Application No: LU/151/21/PL
Site Address: 25 River Road Littlehampton BN17 5BZ
Description of works: Demolition of existing car garage and the erection of 2 no. two-storey residential buildings comprising 5 no. flats with associated works. This site affects the character & appearance of the Littlehampton River Road Conservation Area & is in CIL Zone 4 (Zero Rated) as flats.

Thank you for your internet representation made on 13th June 2021 which has been recorded as an objection with the comments as follows:

OWPC37383

drawing Proposed Site Plan

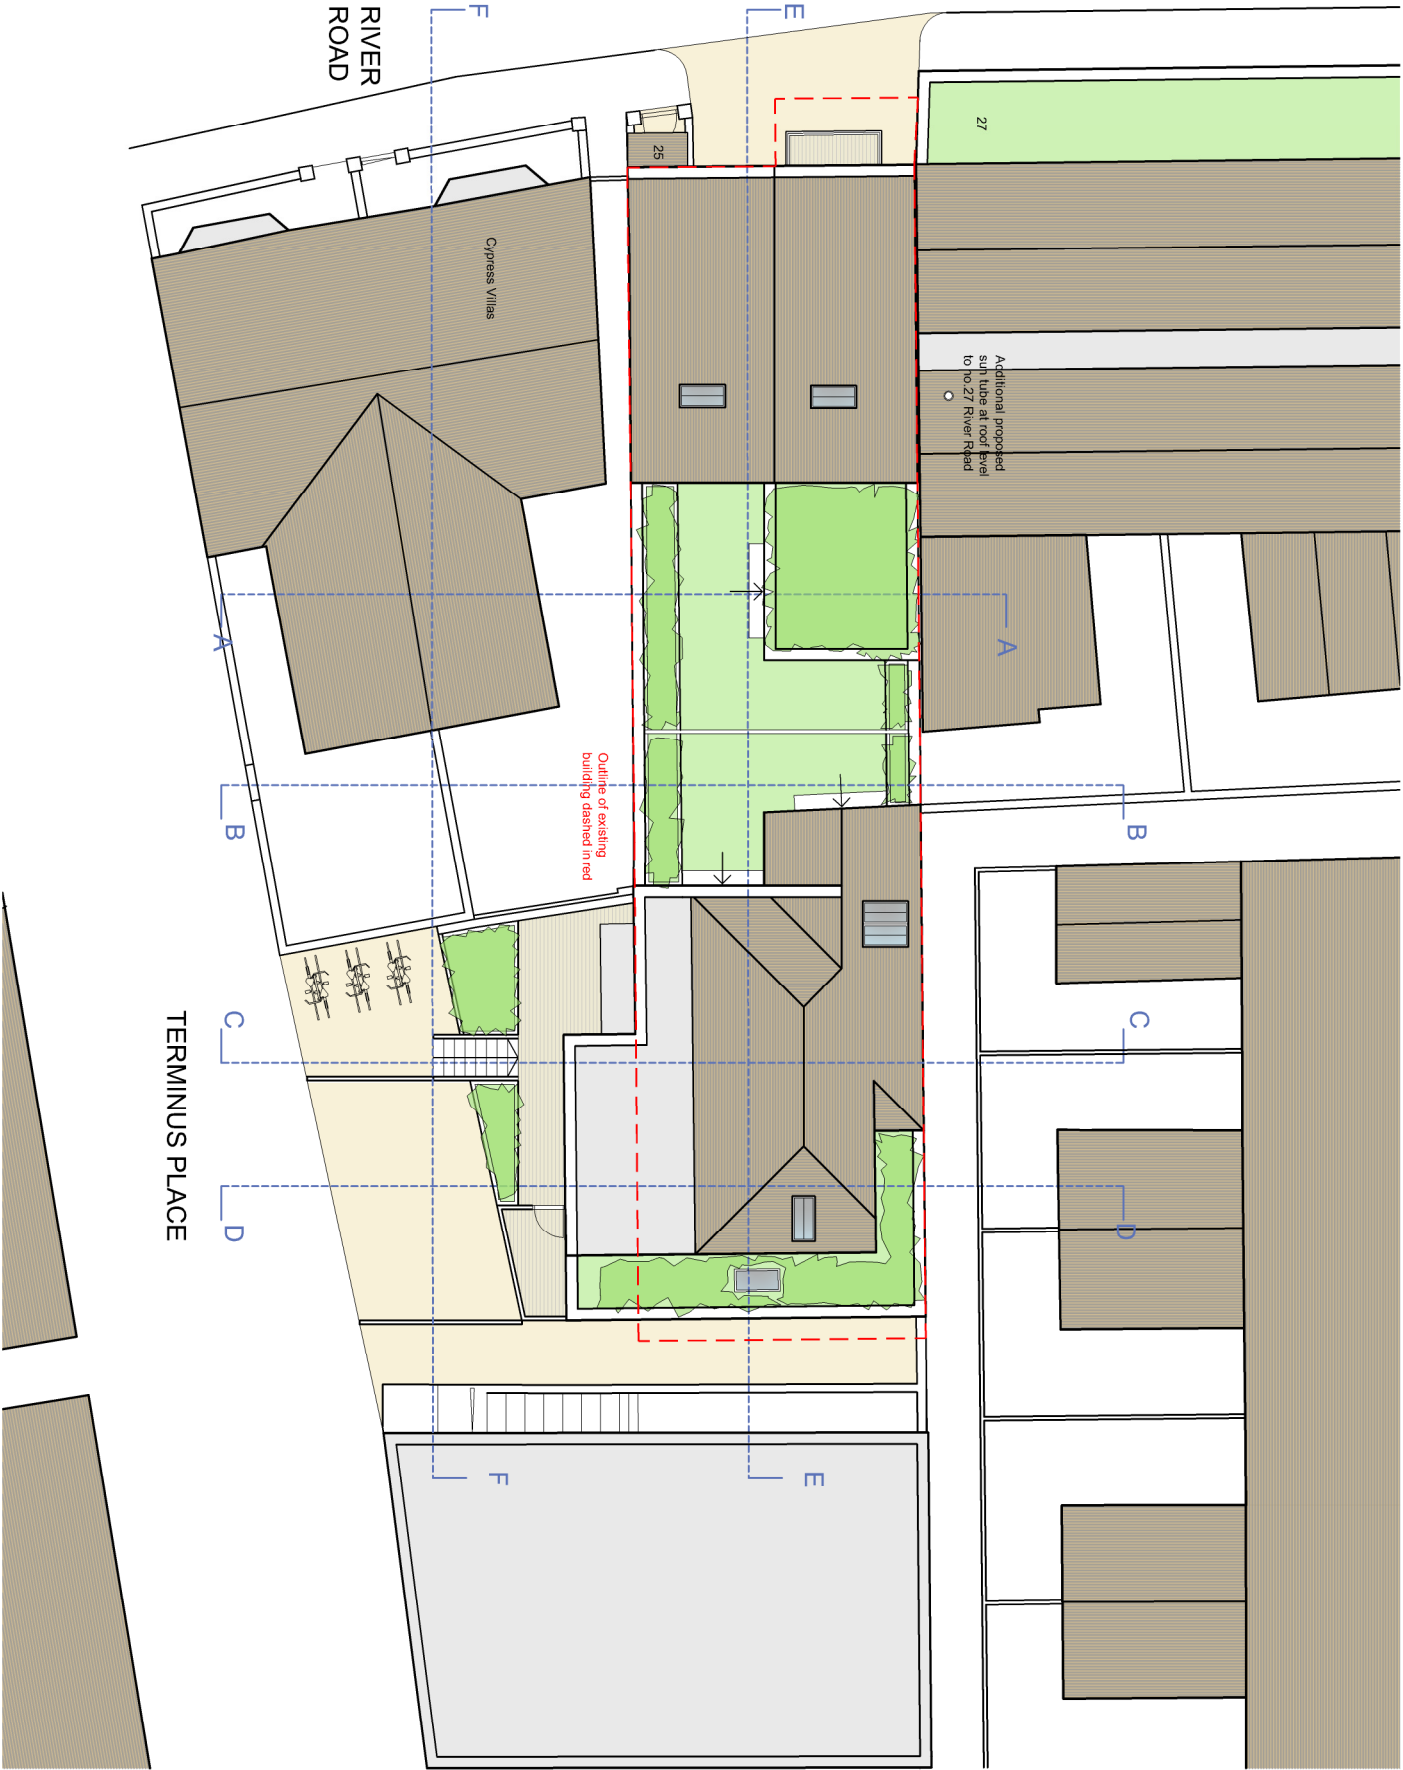
The introduction of parking open to the street on the River Road frontage will give rise to an inappropriate and negative feature in what is a small, domestic scale street scene in this part of the road. Every effort was made in the nearby East Bank Redevelopment, for instance, to ensure that there were continuous, unbroken, built forms along street frontages and parking was provided away from or behind these frontages. It is accepted that there are some limited examples of garage parking accessed directly from the street further to the west in River Road but it is either set well back from the road frontage or is an early example e.g Britannia Quay; the latter significantly detrimental to the street scene.

All parking would be better provided at the rear of the site and accessed from Terminus Place where car parking already exists. This would require a reduction in the number of residential units but the proposed Terminus Place block is too large and overbearing in any event. If any residential development is, or can be, provided on this part of the site then it should be single storey or 1.5 storeys in height.
